H22-0077-25 - Rural exception site of 24 affordable homes, Land off Broadgate Weston Hills

a) LCC Highways – Response dated 12 March 2025 Requests that the Local Planning Authority request the applicants to provide additional information as set out below.

DRAWING NUMBER
622-S11-00-SI-SK-C-9000

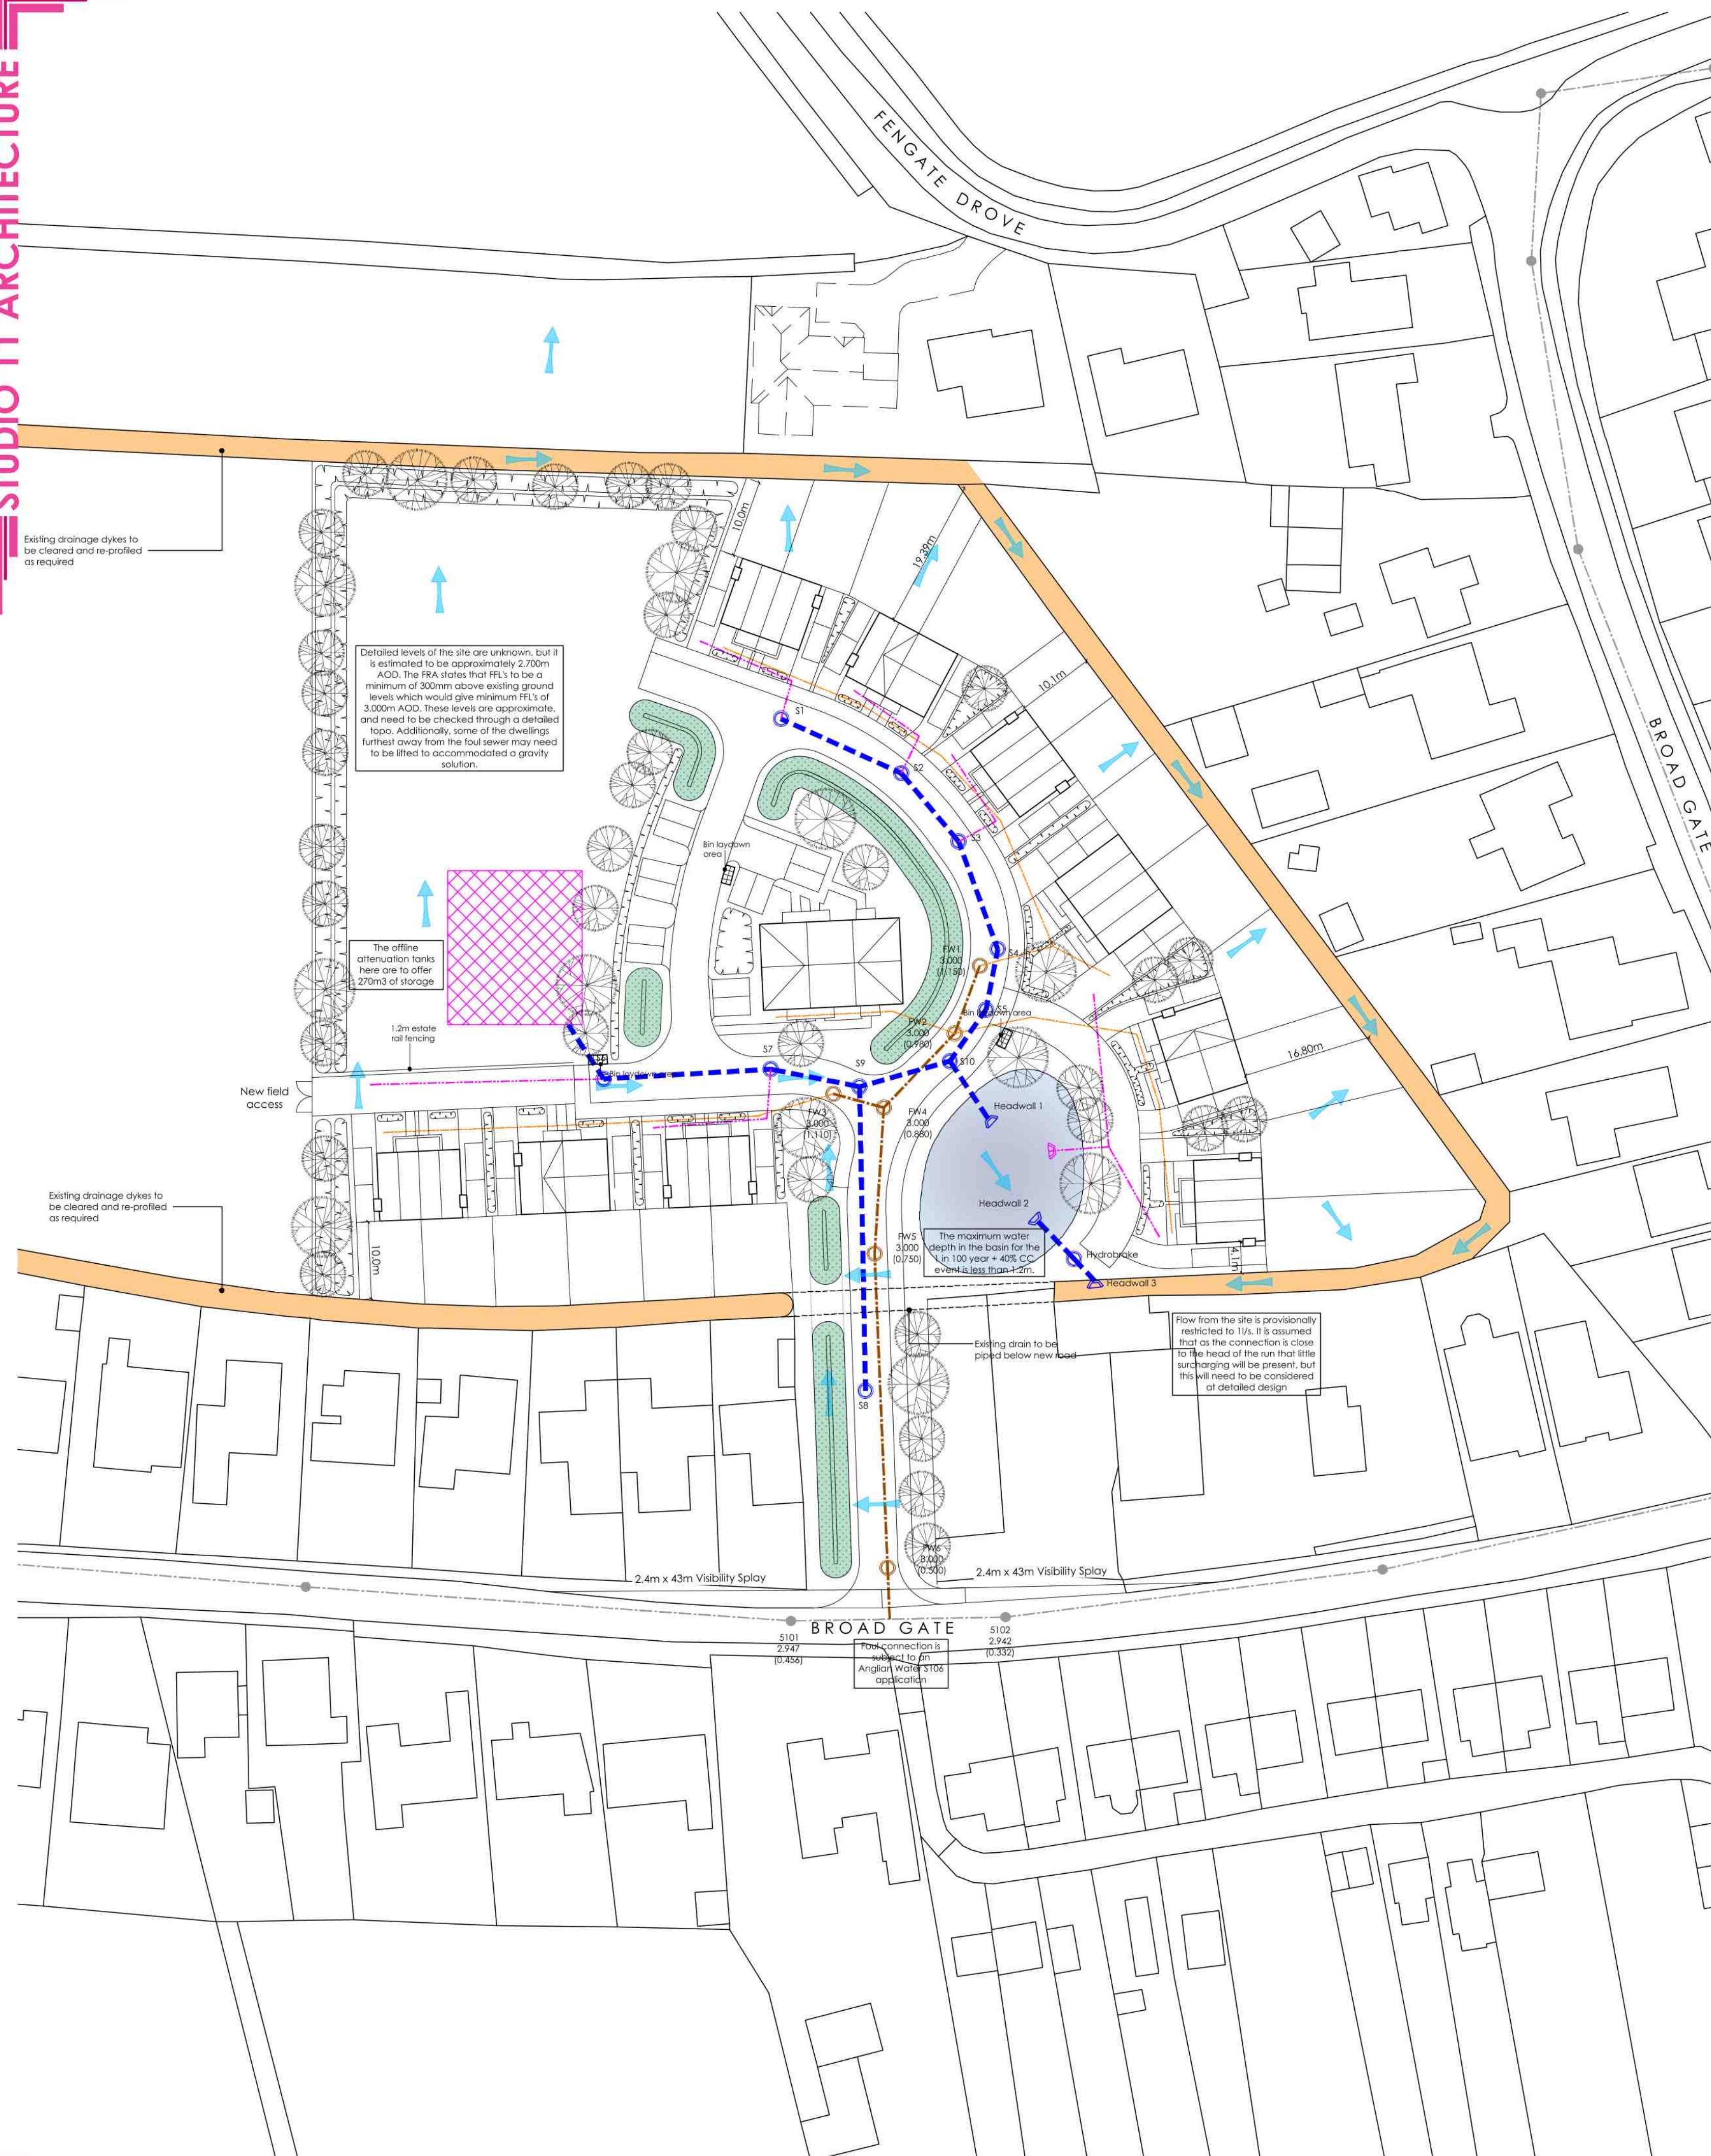
What is the construction of the foundations – how close will they be to the base of the swale?

1.0l/s will be difficult to achieve, how? Consent to discharge is required from the IDB.

A Flow control device is not shown. The design needs to be more detailed for this type of application. A contour drawing, levels, maintenance regime, flood flow paths should be submitted.

622.SL.01

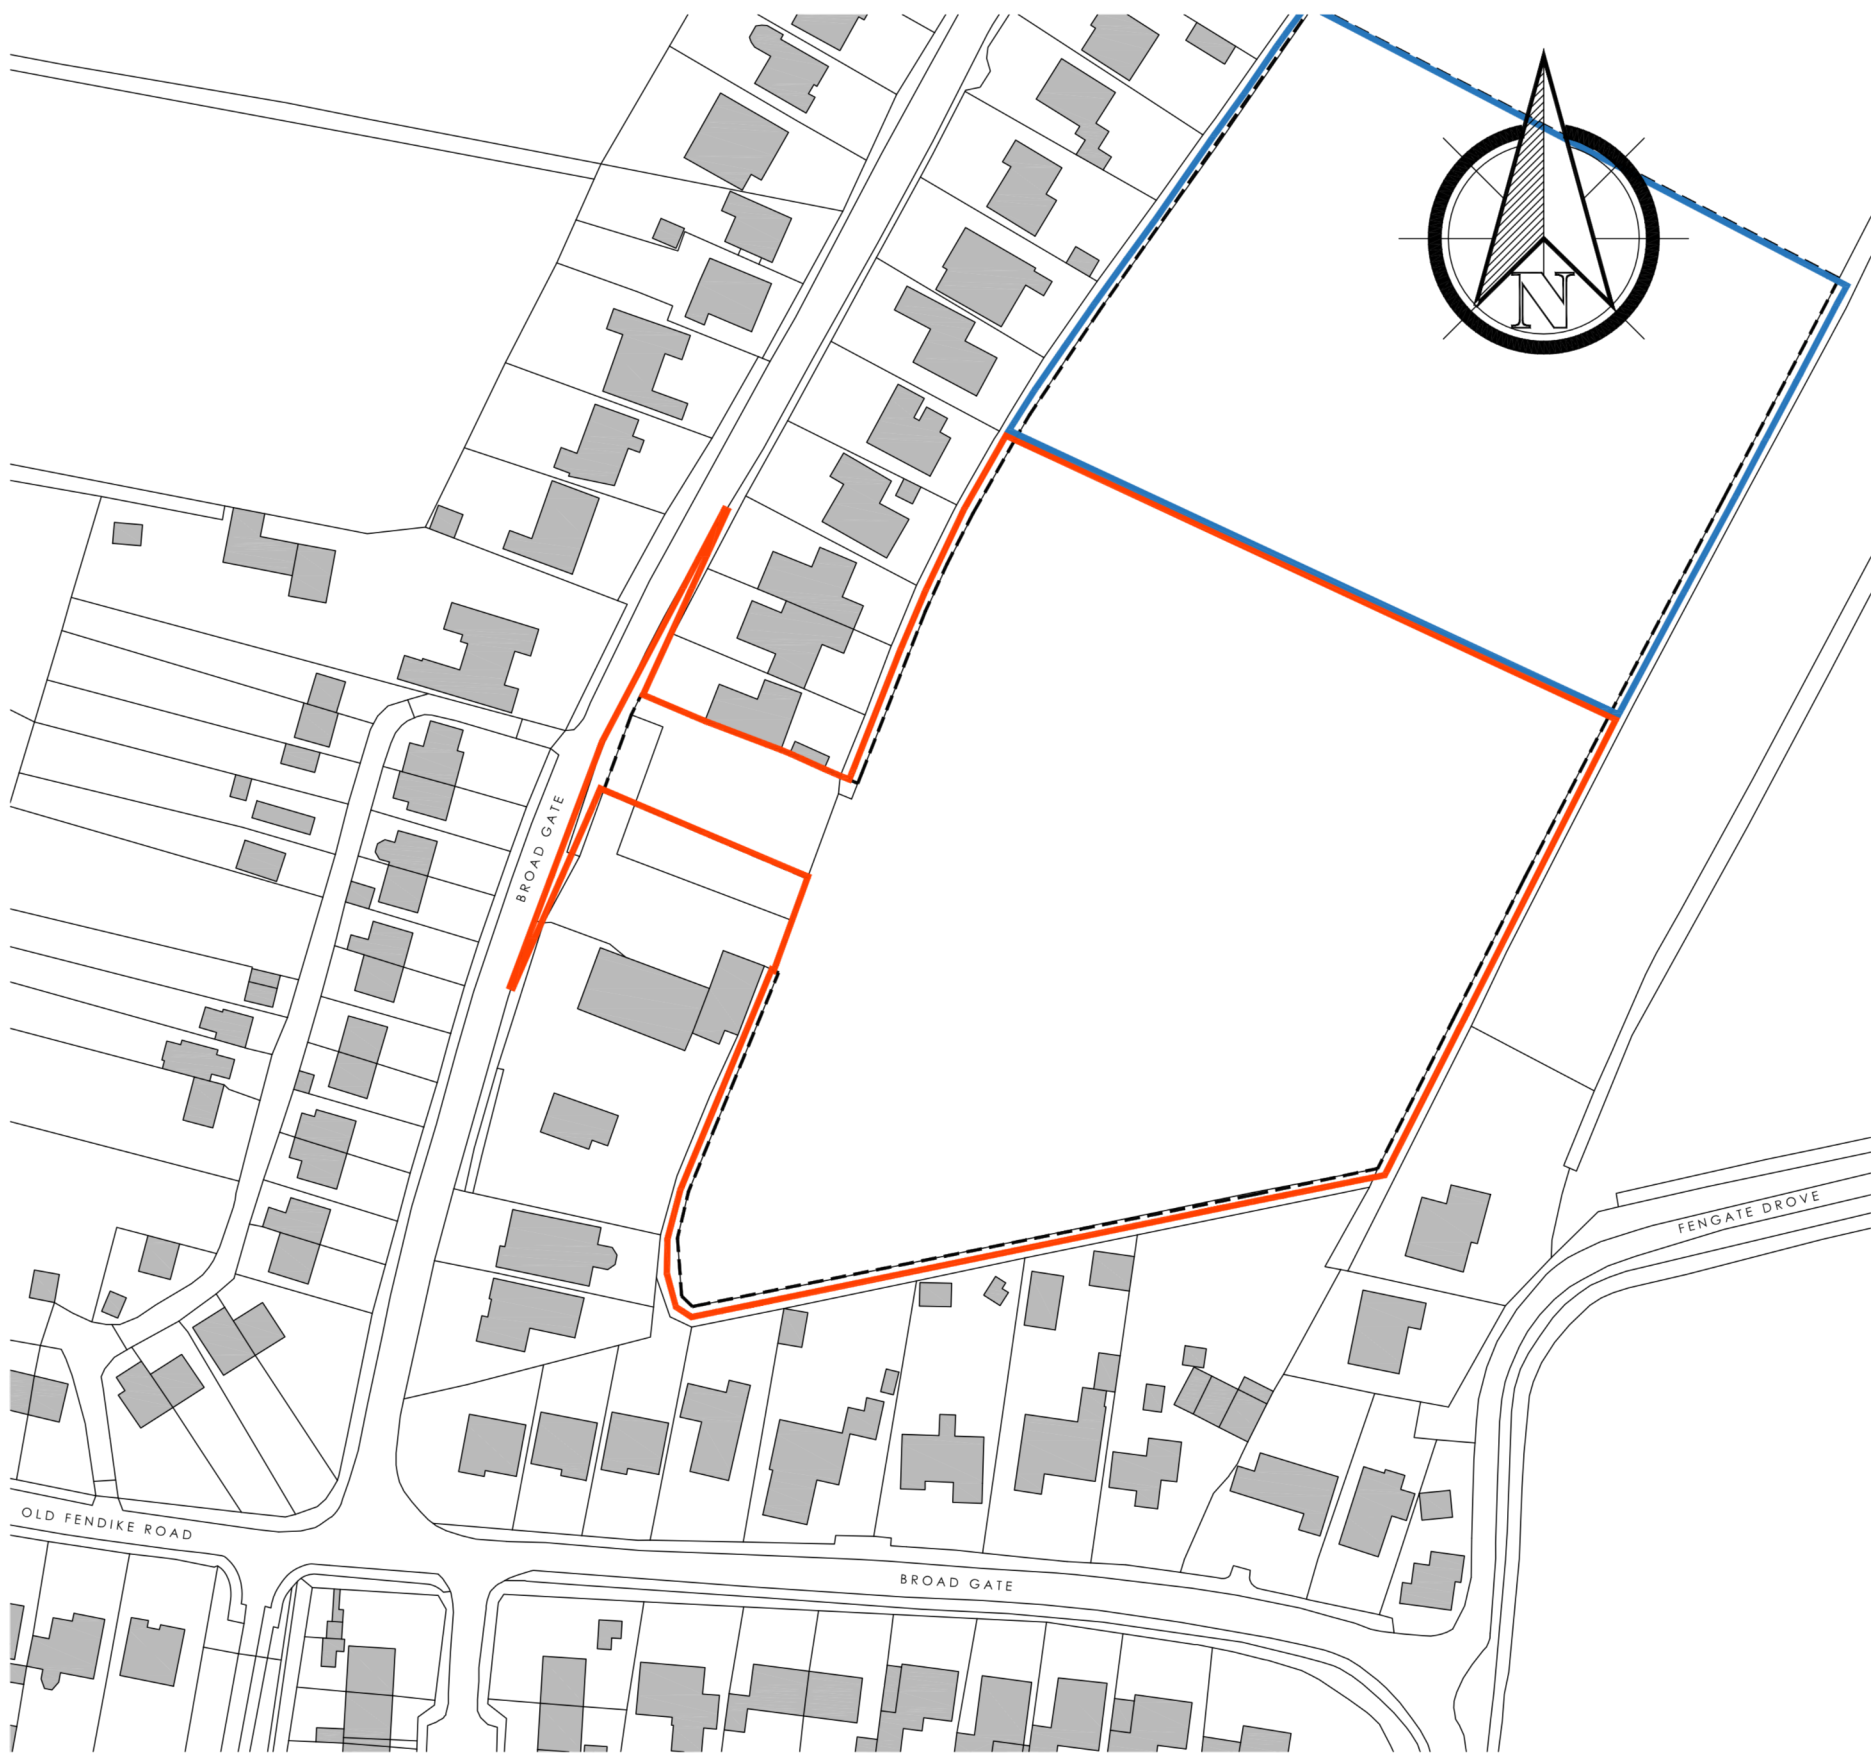
Carriageway and footway widths should be detailed on the site plan.

Central private drive to be changed to an edge lane to provide connectivity.

What are plots 7-12? They don't have their own garden space. The parking is too far away from some units and this will lead to indiscriminate parking in the area.

The footway at the end of the road close to plot 13 serves no purpose and should be removed – it only needs to go up to the drive way to plot 13.

Tactile paving should be detailed at every crossing point.

Secure Cycle storage should be detailed for every dwelling without a garage.

The footway that connects onto Broadgate should provide a tactile crossing over to the footway on the other side of Broadgate so pedestrians can access the existing footway network.

How will they maintain the ditches to the rear of the dwellings (plots 13-24).

They need to futureproof the design as the landowner owns the adjacent land (blue outline) – the attenuation pond should be big enough for both plots of land.
